824-Acre Curtis Road Development Traffic Impact Analysis

(LSC #184750)

P-18-008

SUBJECT: P-18-008 – 629 CO SPings
First Submittal

Figure 2
Site Plan

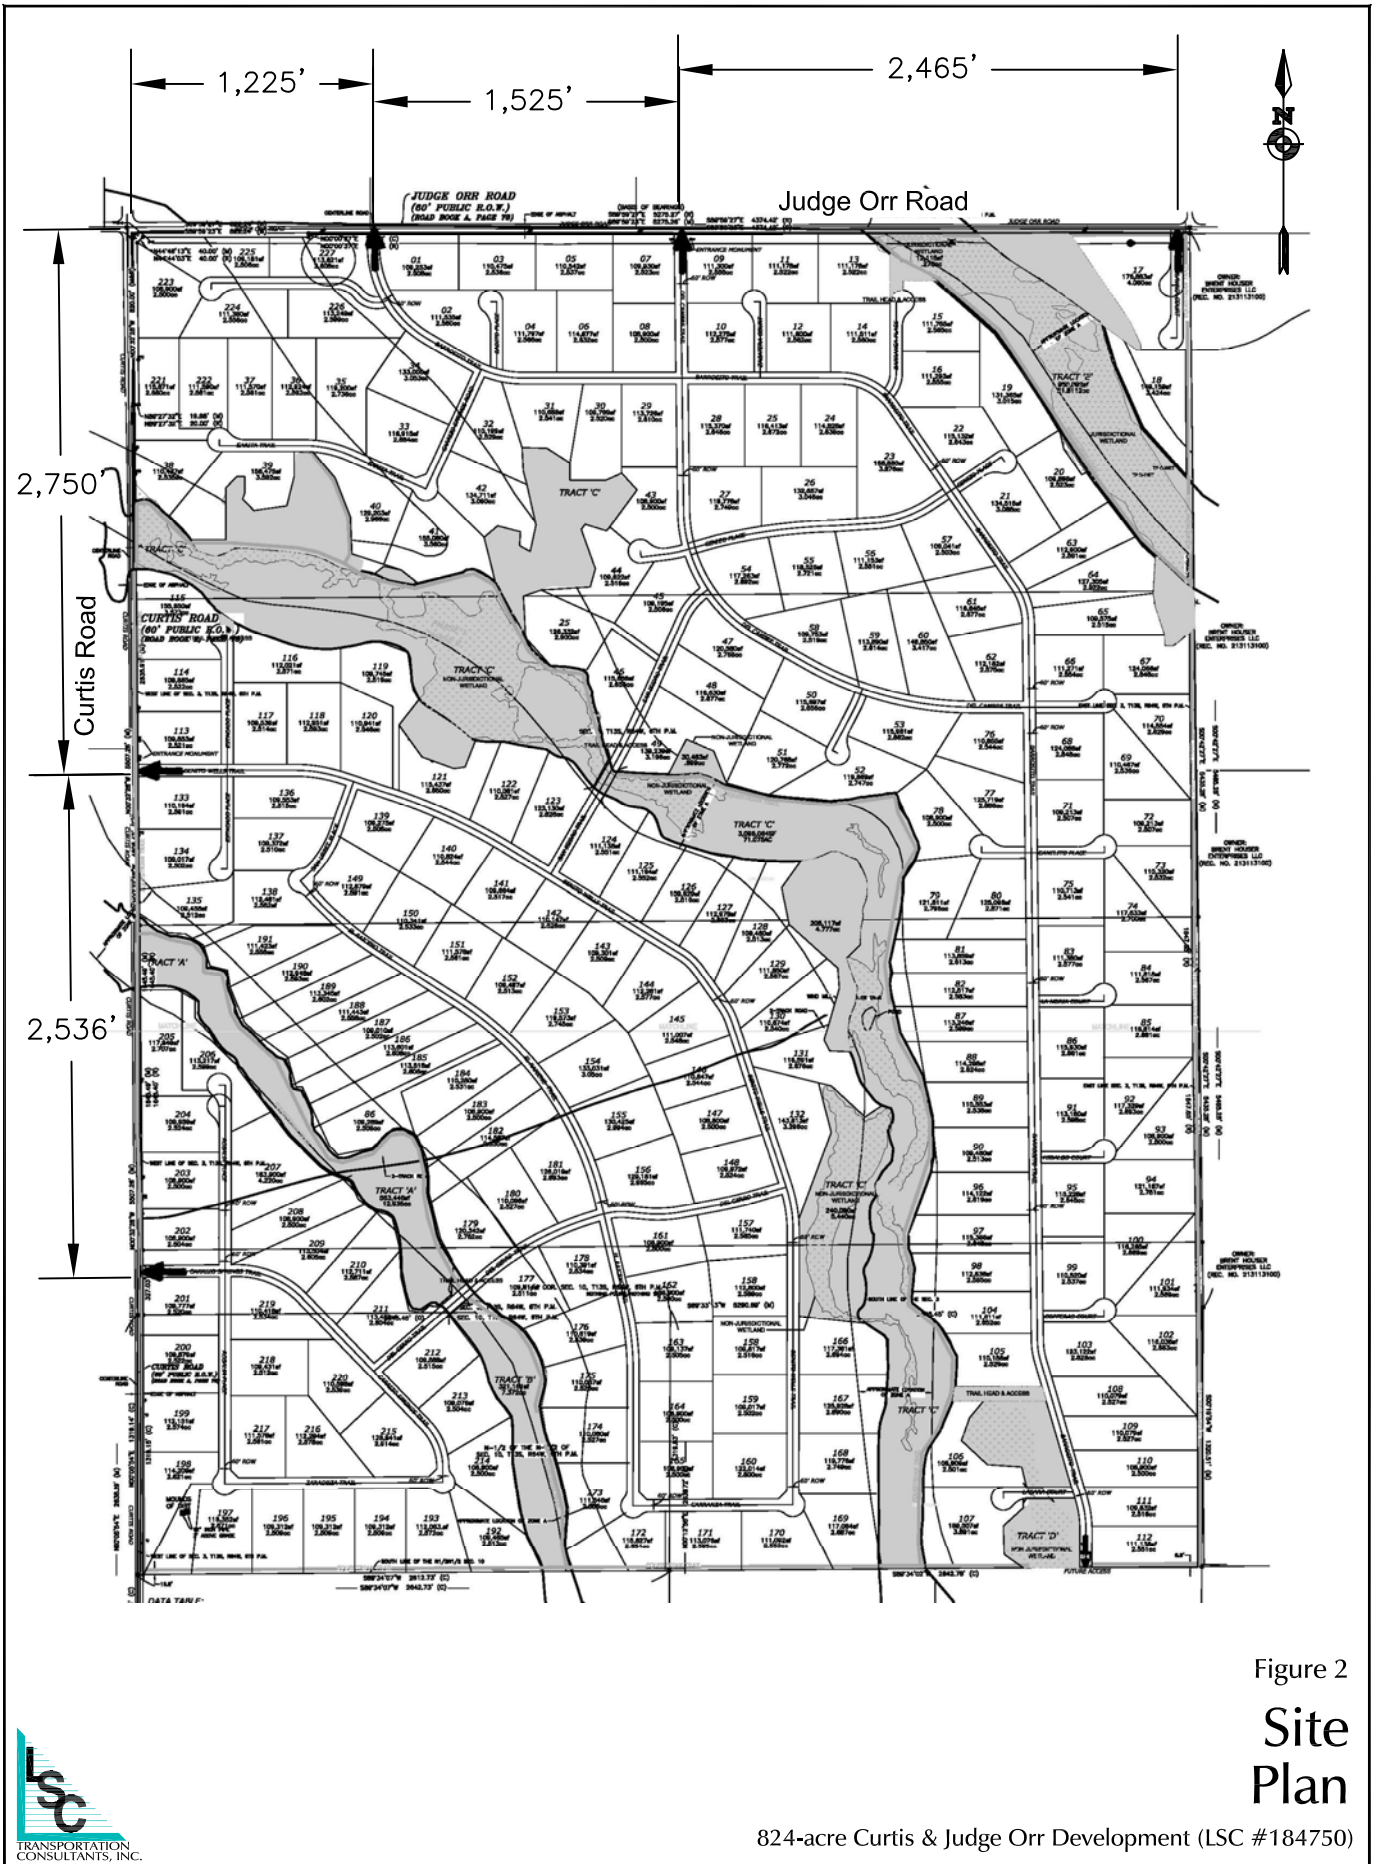
Requires the submittal/approval of a deviation request for intersection spacing.

This deviation has been prepared and submitted for the spacing just east of Curtis Road.

The easternmost roadway intersecting Judge Orr (shown as Lavaca Ct. on the plan included with the initial submittal) has been changed to a driveway to serve two lots. The equestrian trail has been shifted to the west side of this driveway and the driveway has been shown as close as possible to the property line. The intent is that once the property to the east develops, there would be the potential to include this driveway in the width of a future public road aligning with Elbert Road.
